**Land south of Ford Lane and East of North End Road, Yapton
Application for Non-Material Amendment**

Please accept this letter and enclosures as an application for a Non-Material amendment under the Town and Country Planning Act 1990, Section 96A relating to the site layout approved within Reserved Matters consent Y/82/20/RES at Land south of Ford Lane and east of North End Road, Yapton. The following plans and documents have been submitted in support of this application:

Title:
PARKING PLAN

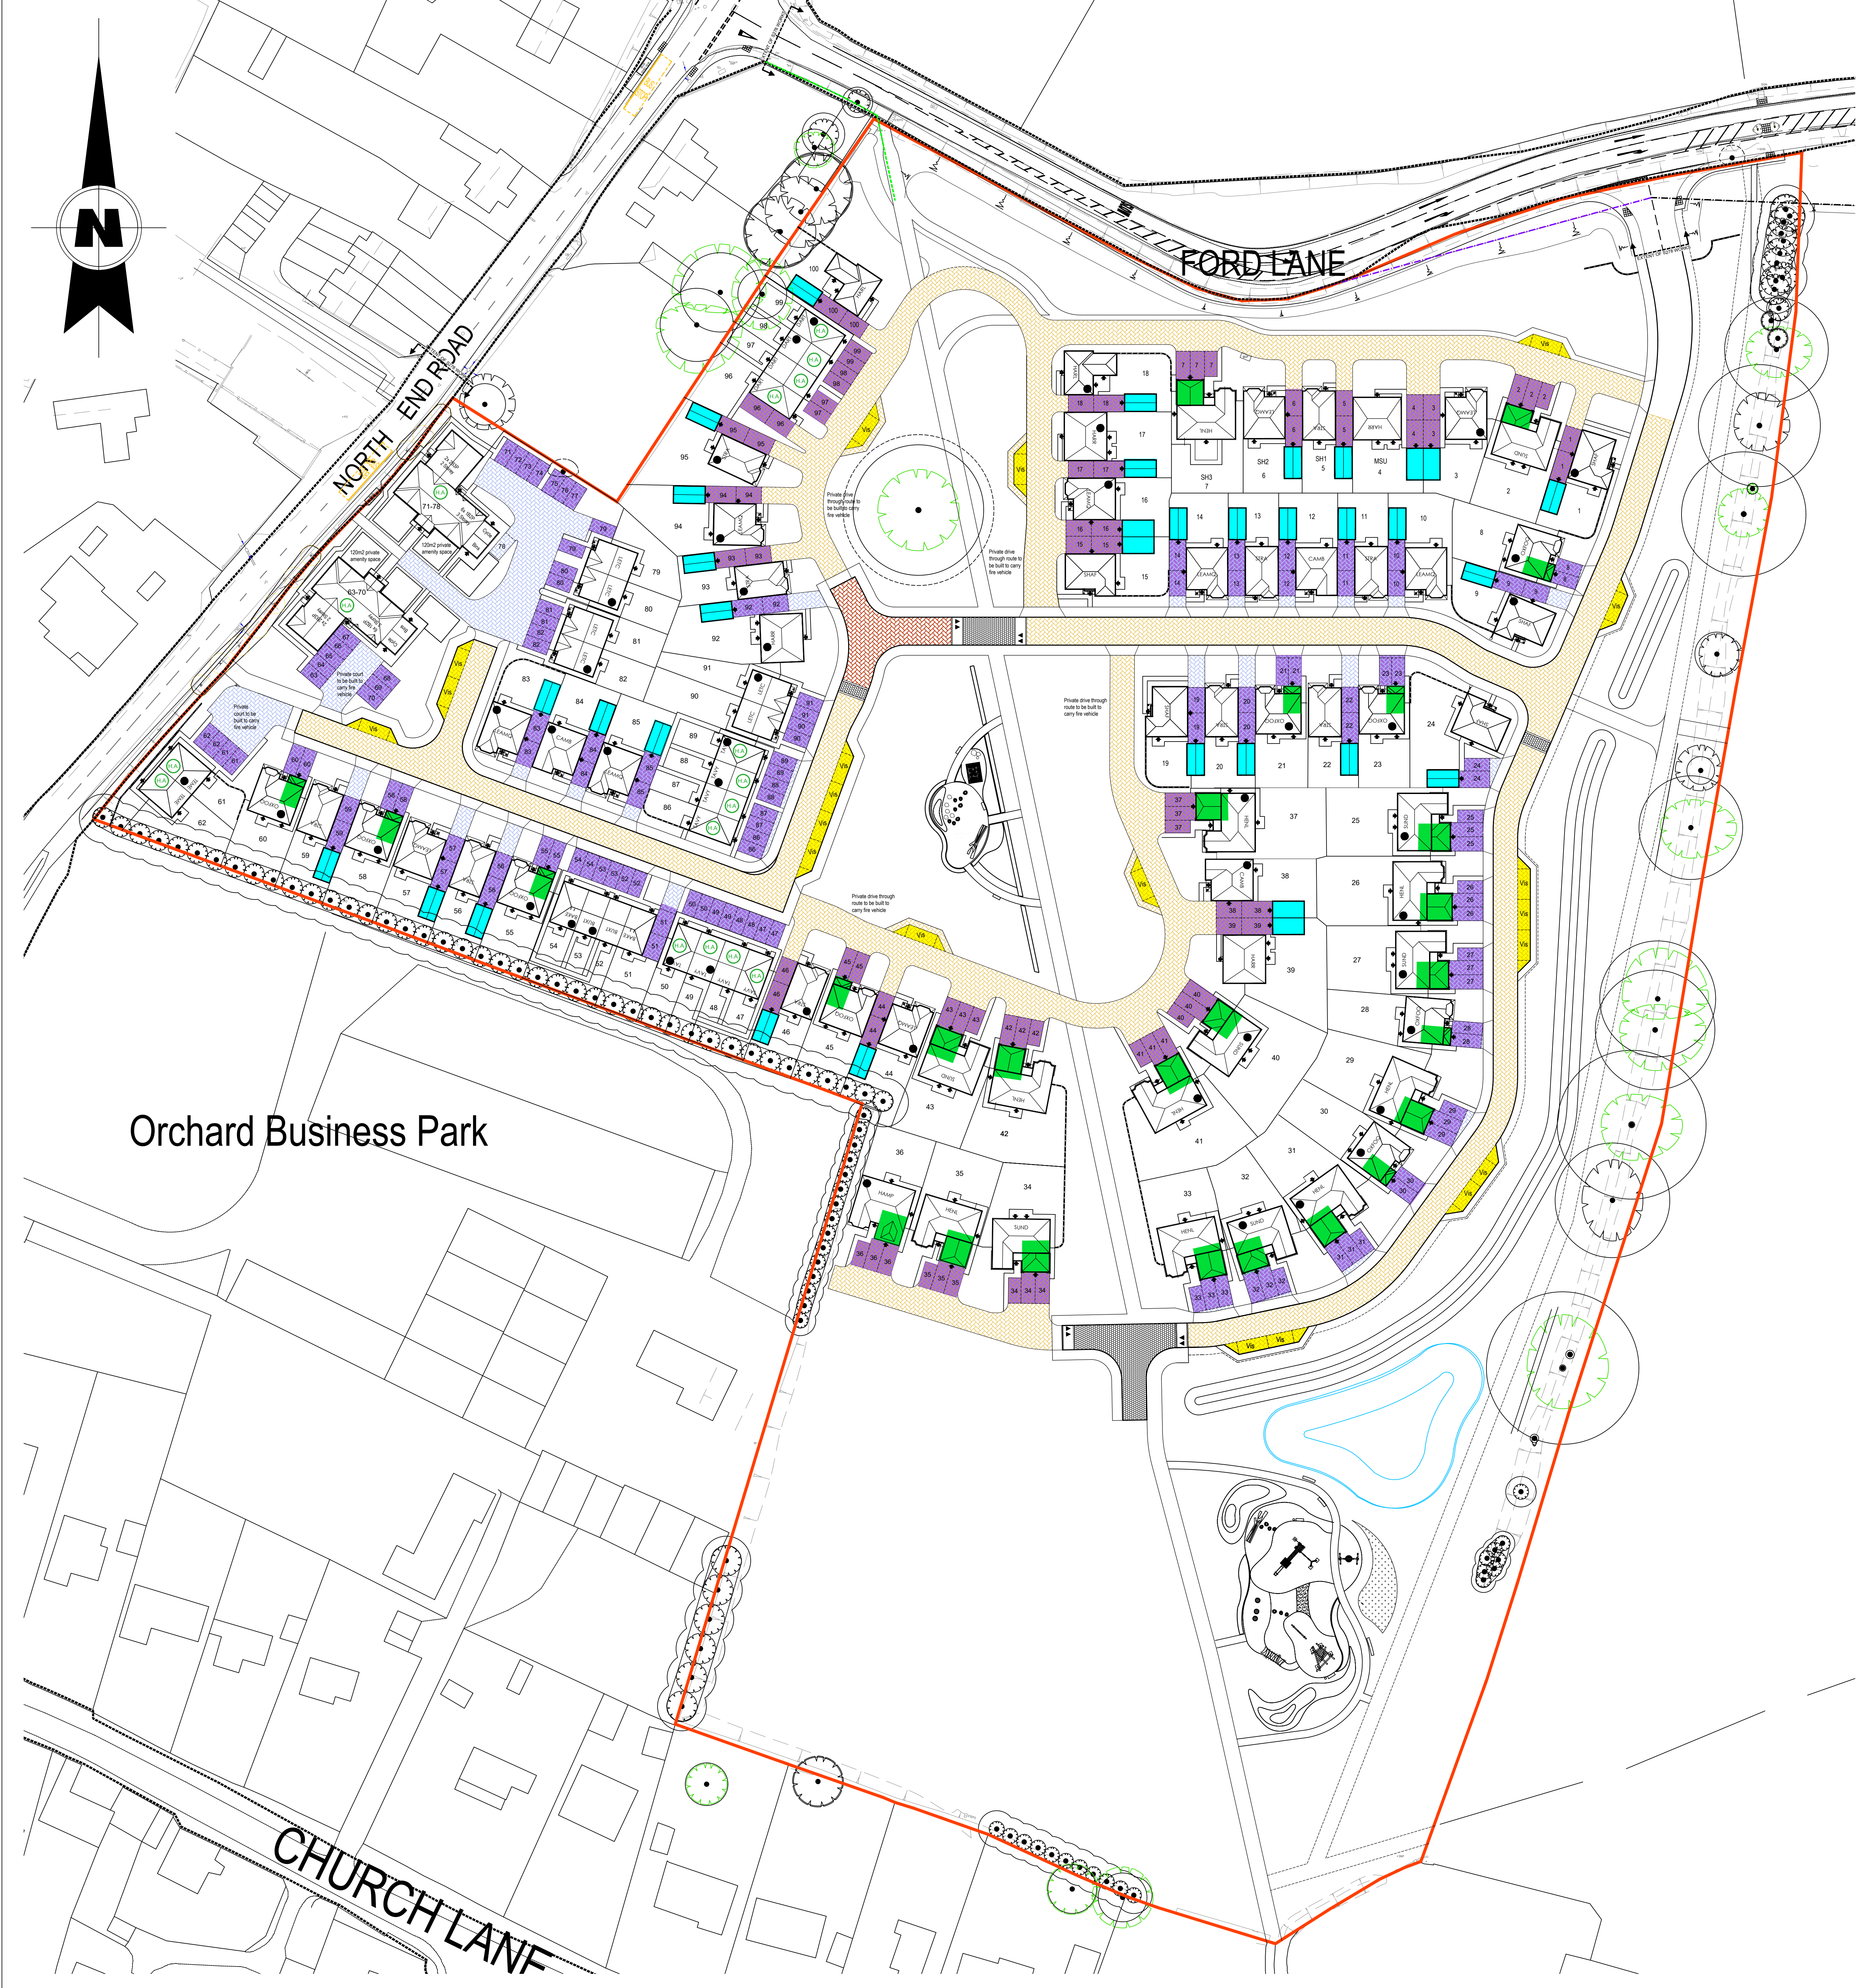
- Footpaths and cycle links have been increased to 3m wide, as agreed within discharge of conditions application Y/131/20/DOC
- Parking spaces serving plots 79-82 have been relocated to ensure adequate health and safety provisions for electric vehicle charging points which may serve the dwellings.
- The pumping station, originally approved to be located to the south of plots 34-36 is no longer required and has therefore been removed.
- The removal of the pump station has allowed for the relocation of the turning head near plot 34, allowing for a better outlook from the properties to the south of the site.
- The play area and SuDs have been moved to the eastern side of the footpath, in the southern area of open space. This change has no effect on the drainage strategy and an updated submission is currently being prepared to re-discharge the relevant planning condition.
